Grindleton Parish Council response to planning application for the Duke of York Grindleton

In the application there is a request for change of use on the public house known as the Duke of York.

Drawing Title
PROPOSED GARAGE PLANS, SECTIONS AND ELEVATIONS

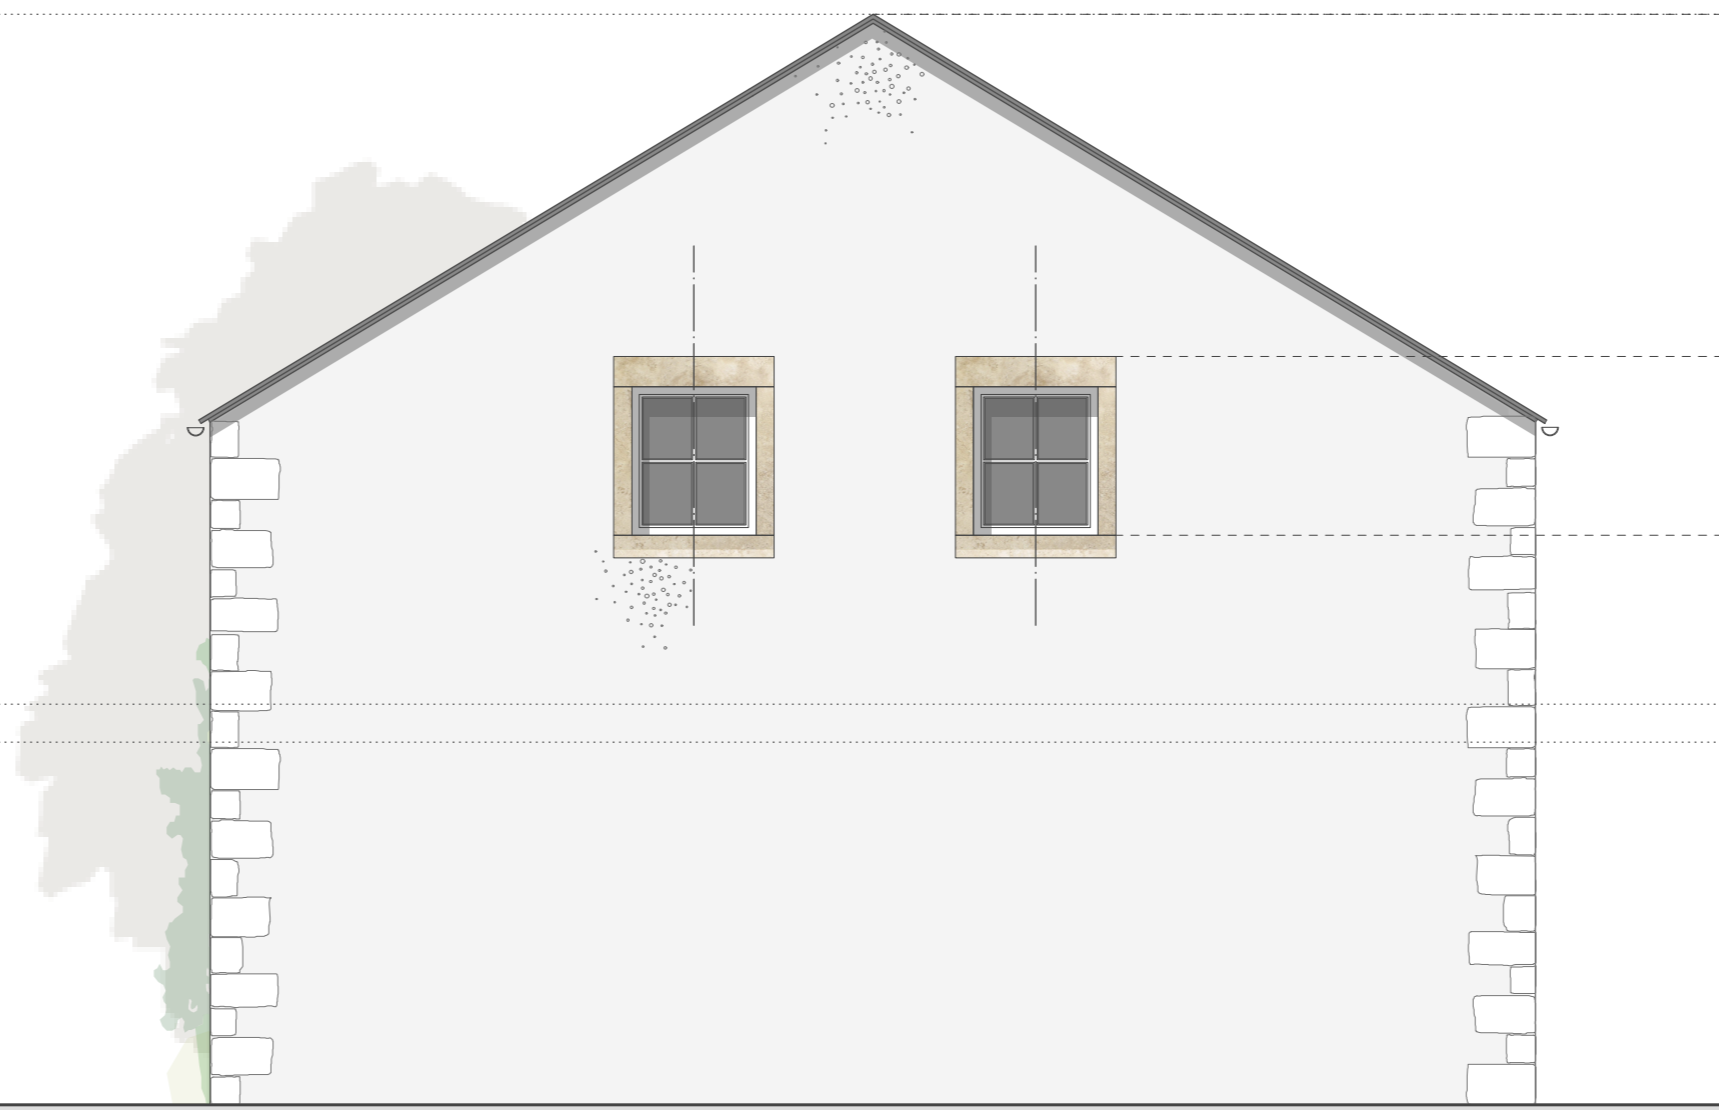
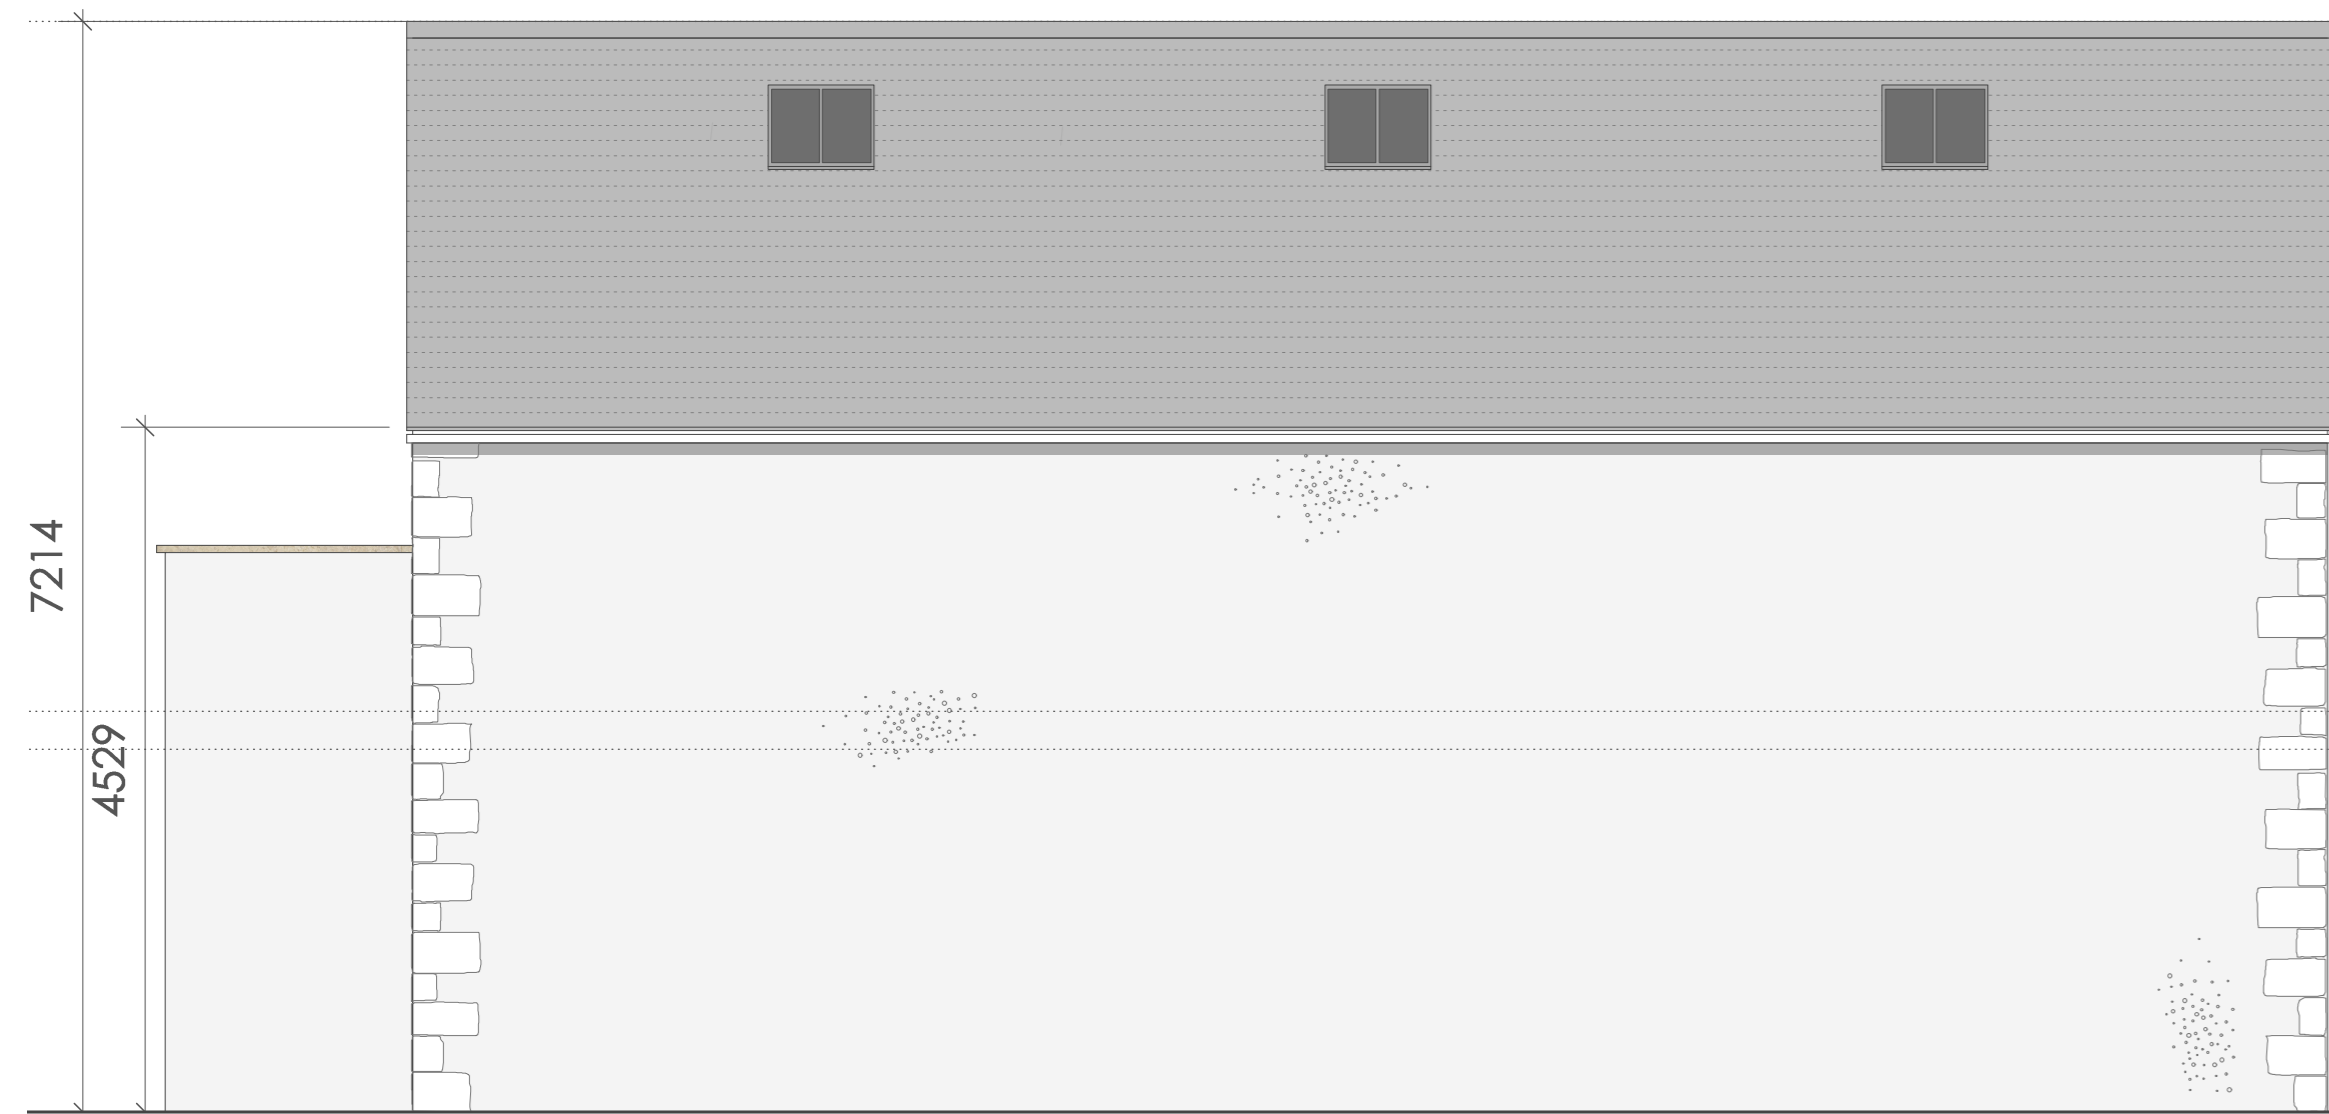
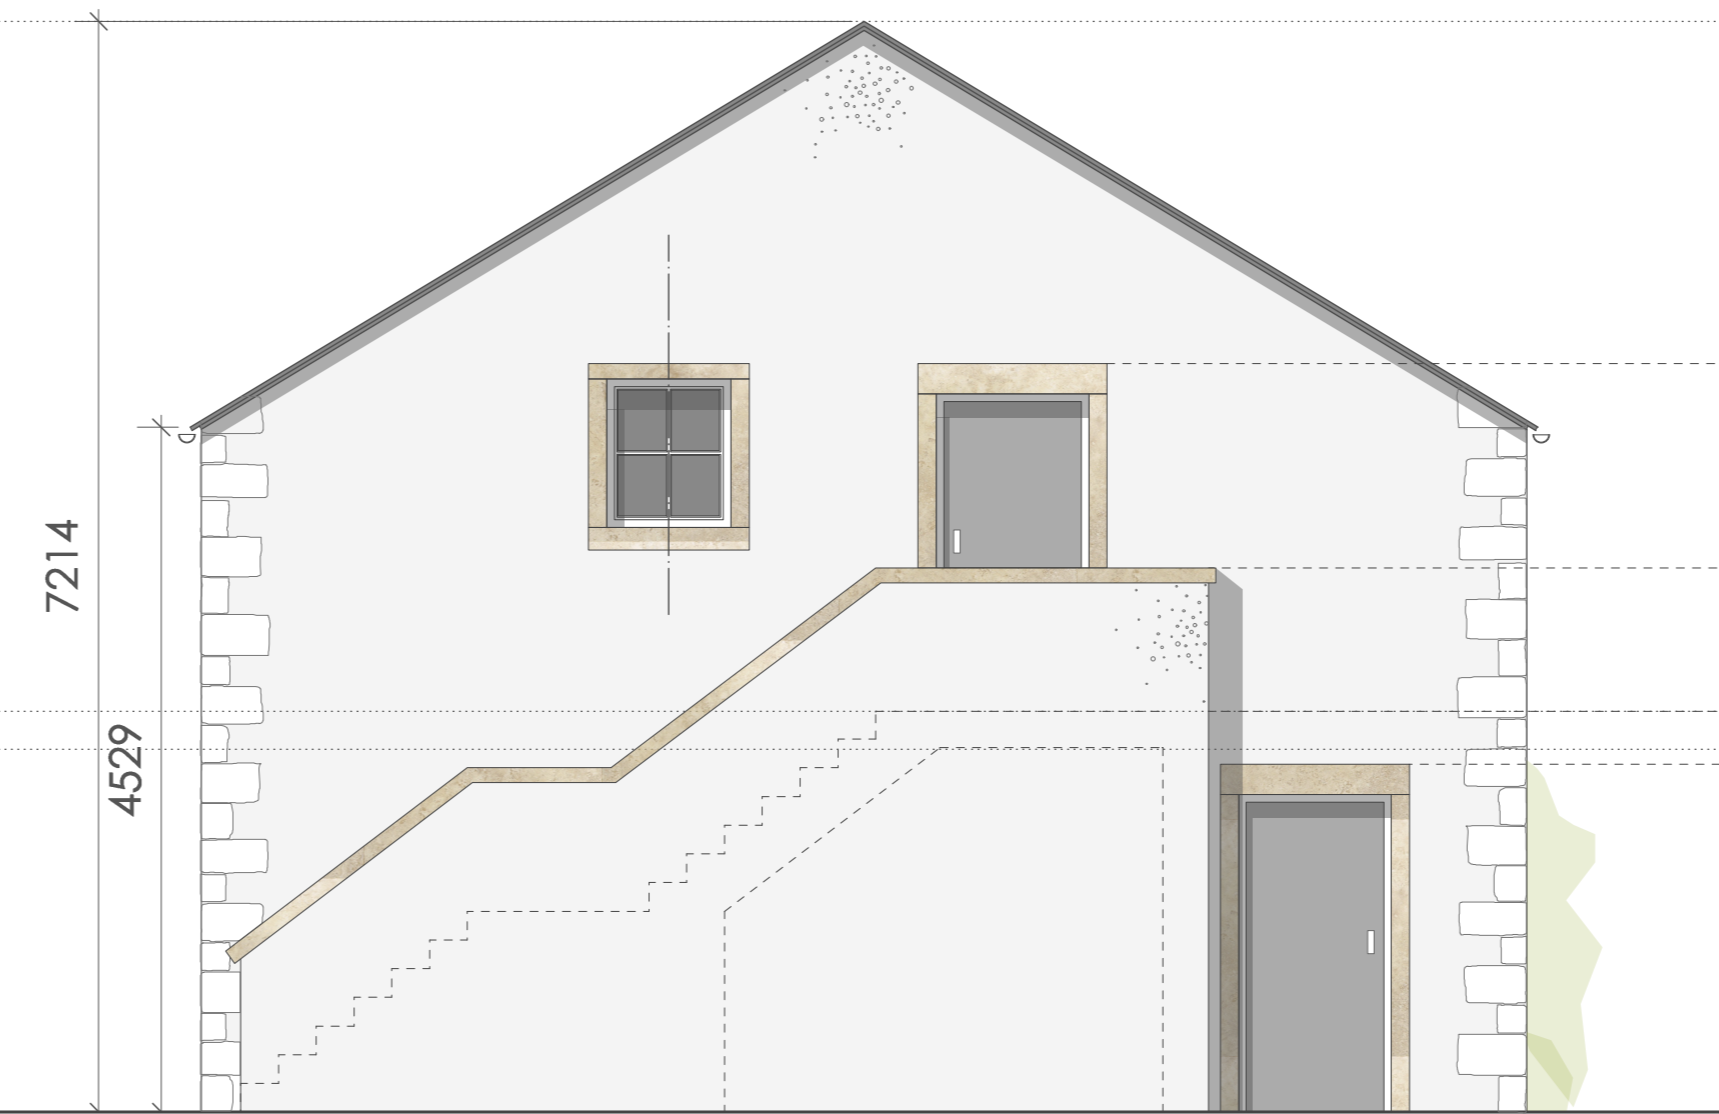
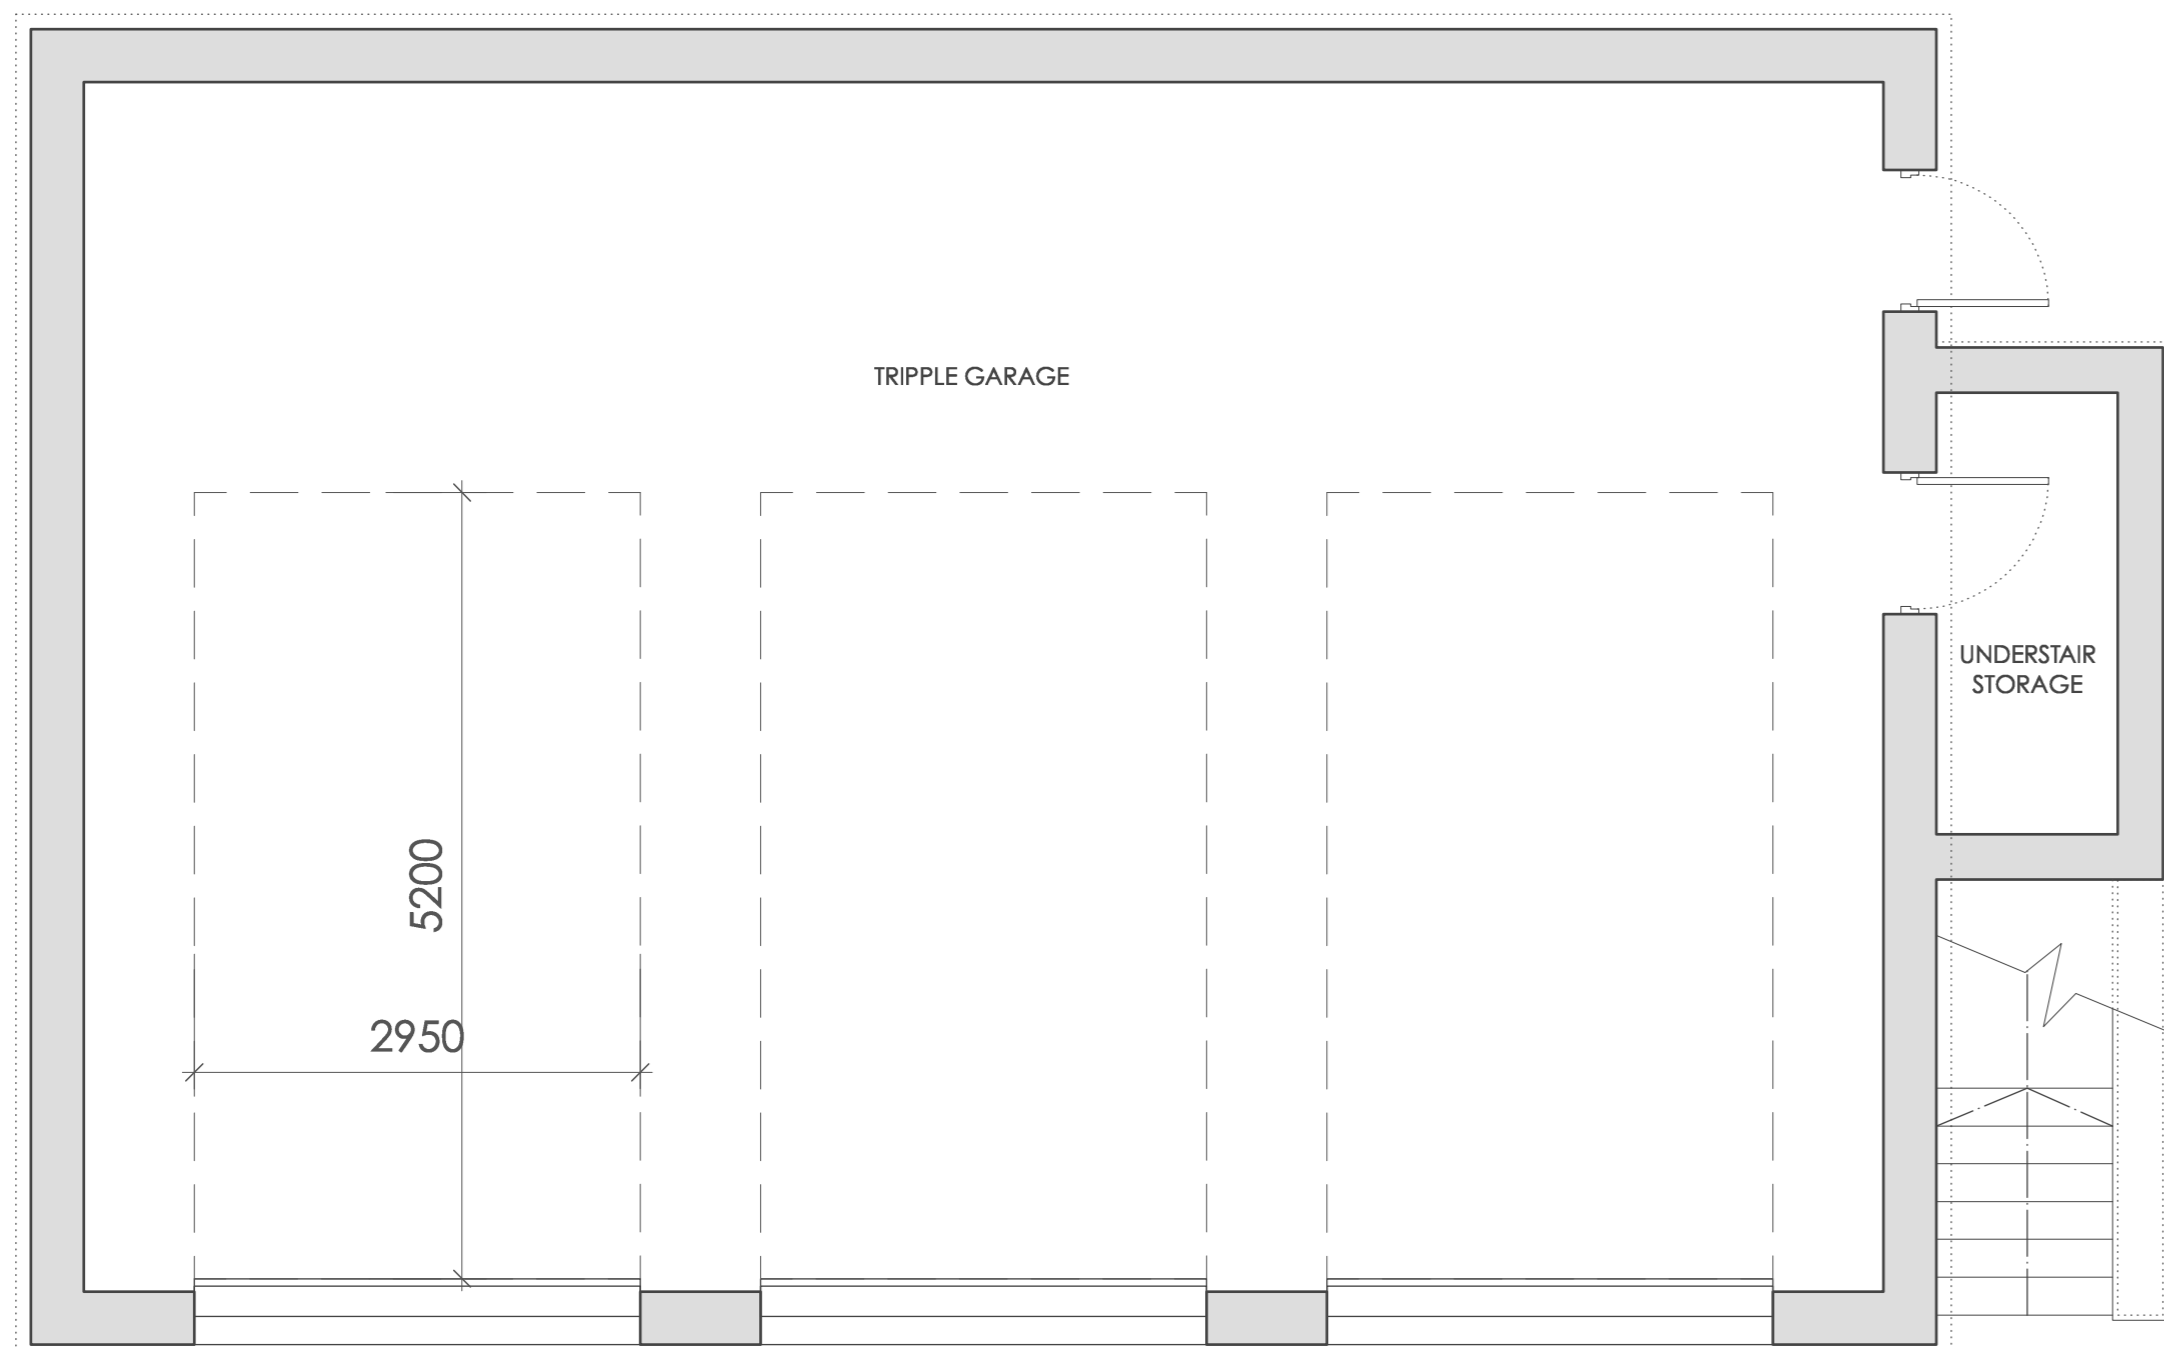
Firstly, in the application it states the building will be a workshop and a store and a depot. If it is a workshop more noise than the application indicates will be generated. If it is a depot this implies it will be used for storage of building materials, sand, stone etc. this would be totally unacceptable due to noise and increase in HGV traffic within the conservation area.

Whilst we agree that a public house created noise that was mainly at given times of the day, with a builder's store this could be from early morning through to late at night. Not with holding this, in the winter will flood lighting be used at unsociable times to light the loading area? Considering the site has houses on two of its boundaries this would be undesirable. The application does say that ladders and scaffolding will be kept in the store. These are noisy when being moved around.

In the application the information says the 1st floor will be used for storage of equipment that they don't want to leave on site. At this stage I would like to add a statement from one of our councillors who has worked in the industry.

"In my 45 years of construction experience and current health and safety legislation of manual handling regulations. I find it surprising a store has been designed where tools, materials and heavy equipment must be carried negotiating a flight of external stairs of at least 16 treads on a regular basis. This equipment can vary significantly from light to very heavy and perhaps a two-person lift. If materials are to be stored as suggested (copper tube etc) then negotiating the limited landing space would be hazardous"

As the store will be used to store high value items we have concerns as to how they intend to apply their security. We would want a restriction on 24/7 flood lighting and at unsociable times.

The builders store is going to be built alongside millennium woods which has been developed over the years to attract wildlife and grow native plants. This is an area that is well used by the villagers. It is felt that the woods would be adversely affected by excessive use of floodlighting from within the depot.
